OBSERVATION/SUBMISSION TO PLANNING APPLICATION

Case Reference: 324113

Re: Observation to the proposed development of open-cycle gas turbine (OCGT) and generator with ancillary equipment.

Location: Pollnagroagh and Rathmorrissy (Townlands), Athenry, Co. Galway

Purpose		PLANNING			
Title		SITE ACCESS SIGHTLINES			
Original Scale	Design/Drawn	Checked	Authorised		
SHOWN at A1	PS	ND	AJB		
Date	Date	Date	Date		
01.12.25	01.12.25	01.12.25	01.12.25		
Status	Drawing Number	Rev			
A2	PEK3-ATK-ZZ-01-DR-CE-901200	0

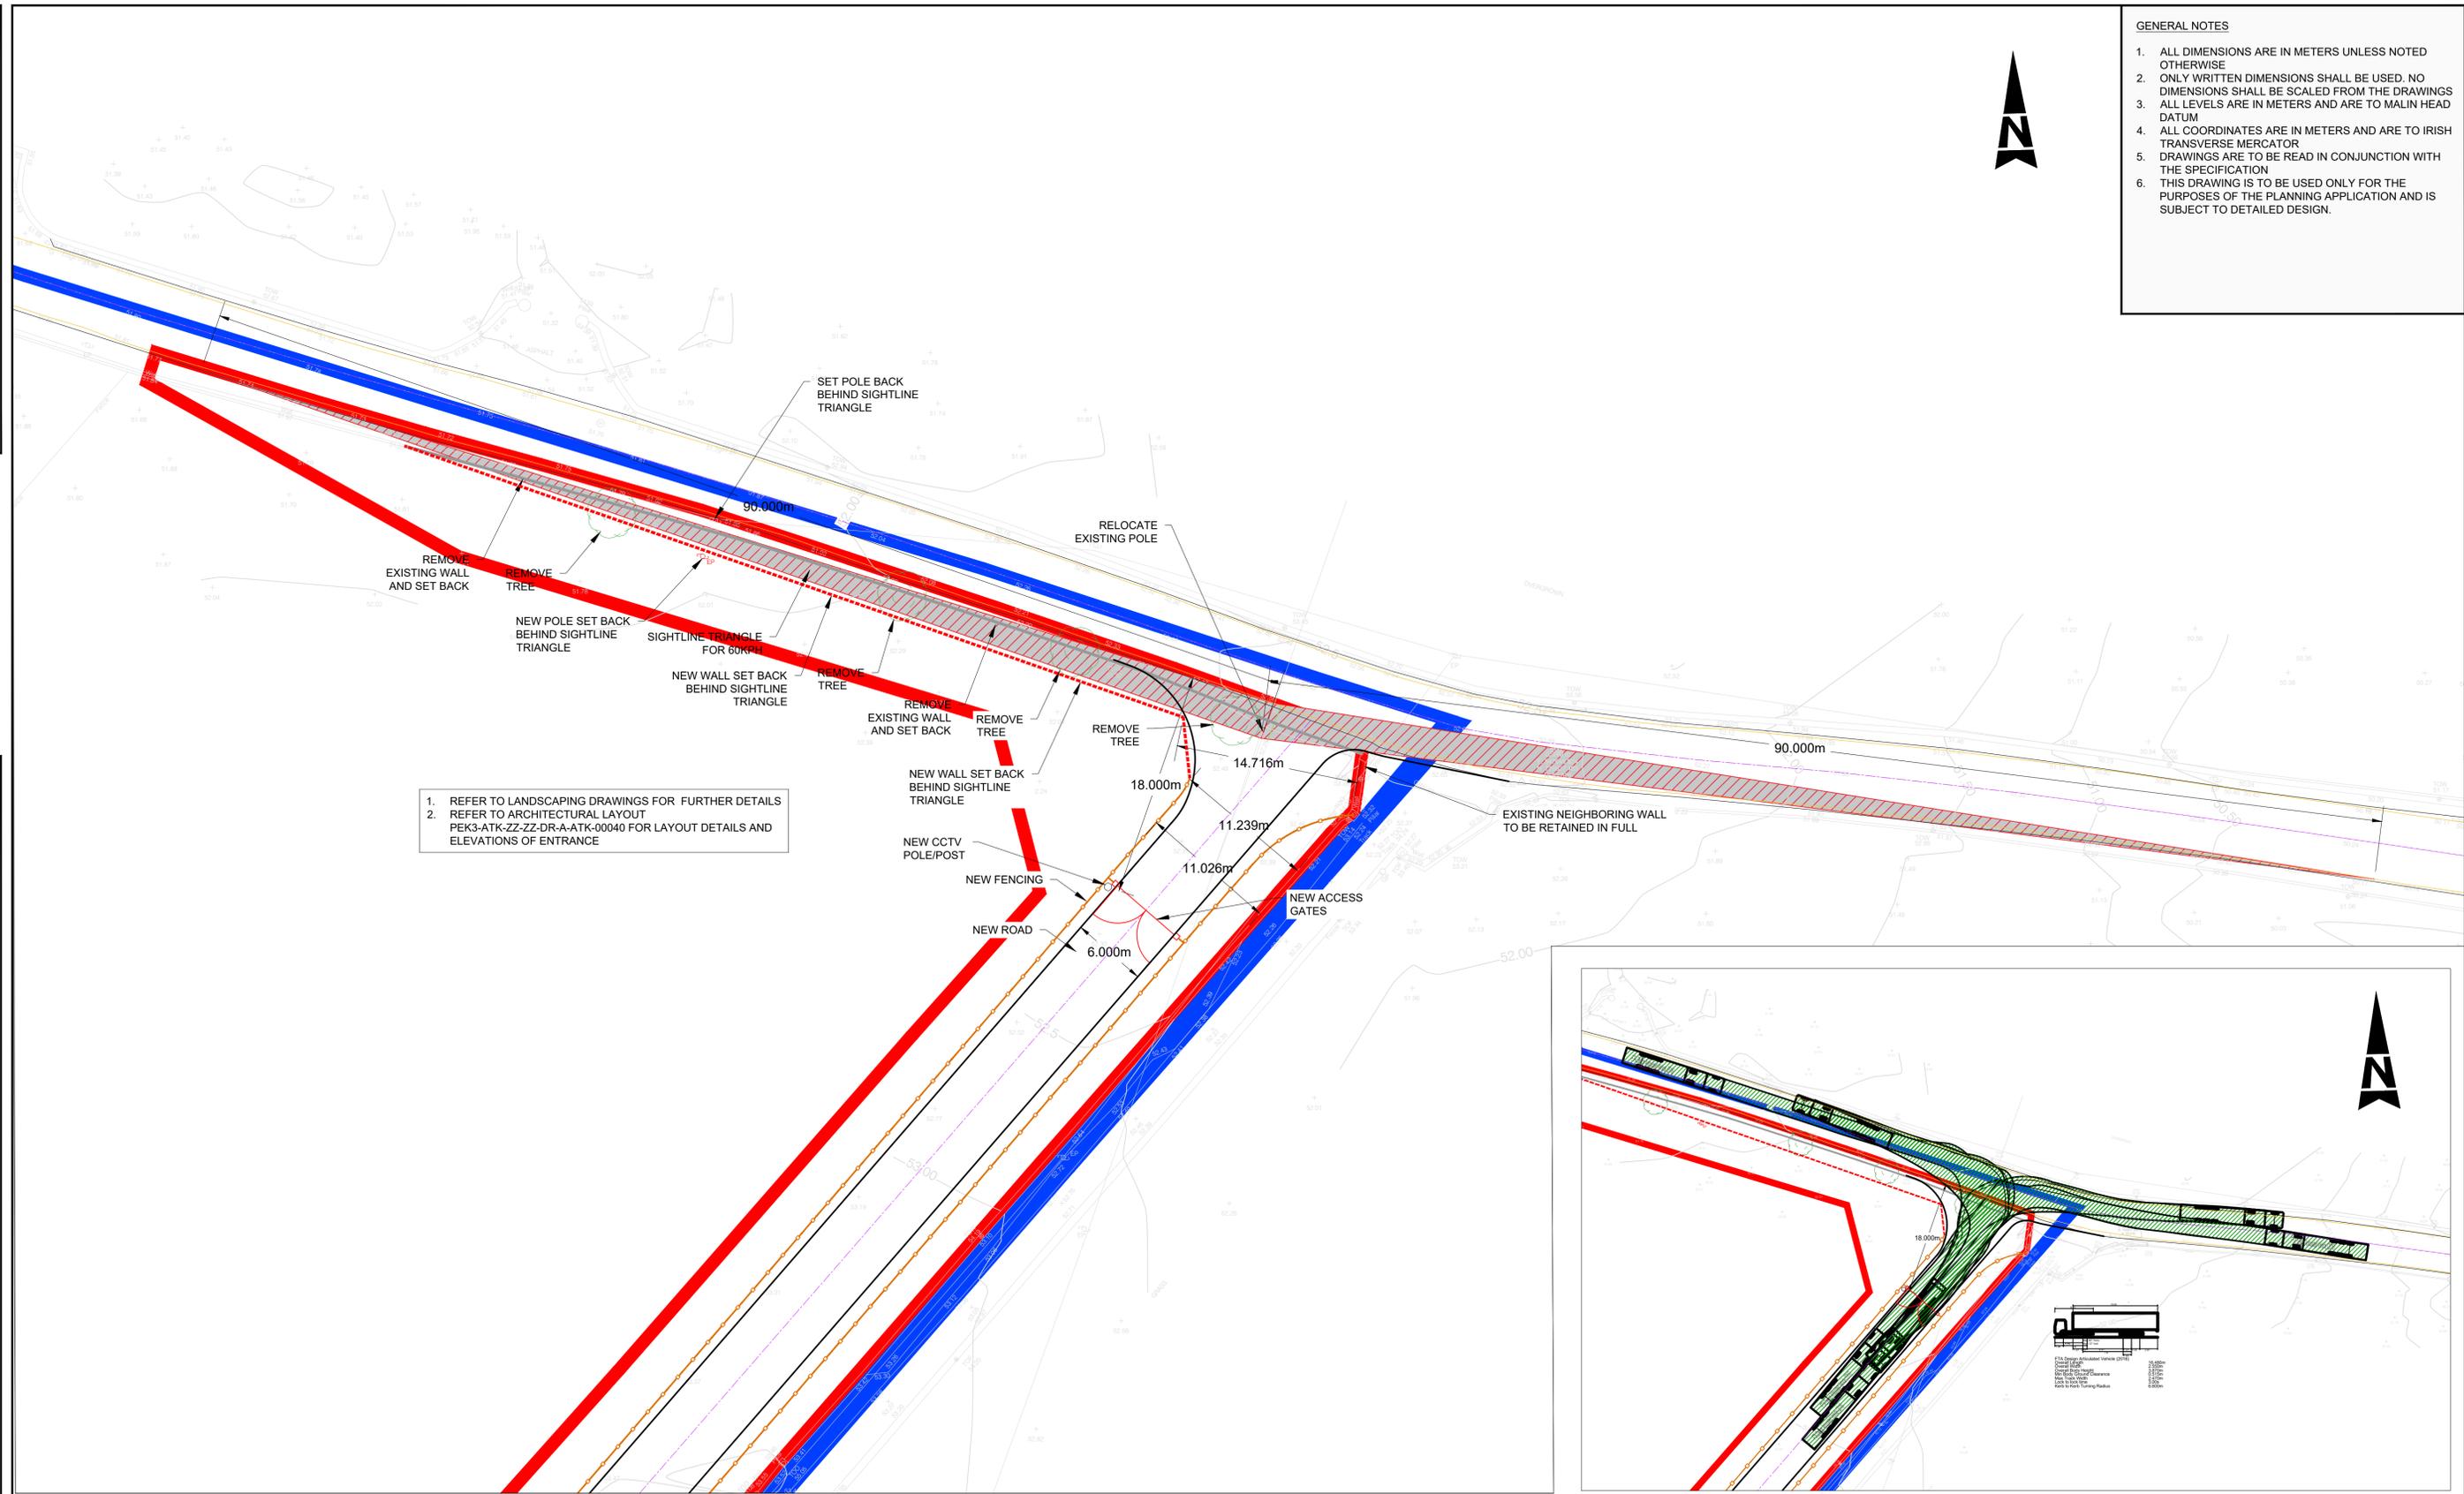
As someone who lives locally and uses this road, I am concerned about road safety in relation to the proposed entrance on the L3103. This stretch of road is already extremely narrow, with no hard shoulder, making it difficult for two heavy goods vehicles to pass safely and leaving no margin for error. Visibility is also poor due to blind dips and sharp bends, meaning drivers often cannot see oncoming traffic in time. The proposed development would increase traffic levels, including heavy goods vehicles, construction traffic, and fuel deliveries such as diesel tankers, all of which require space and clear sightlines that this road does not provide.

Given that these rural roads are used by residents, farm machinery, and school-related traffic, the addition of significant industrial traffic would increase the risk of accidents and create a more hazardous environment. Overall, there is strong concern that the existing road infrastructure is not suitable for this level of traffic and that the associated safety risks have not been adequately addressed.
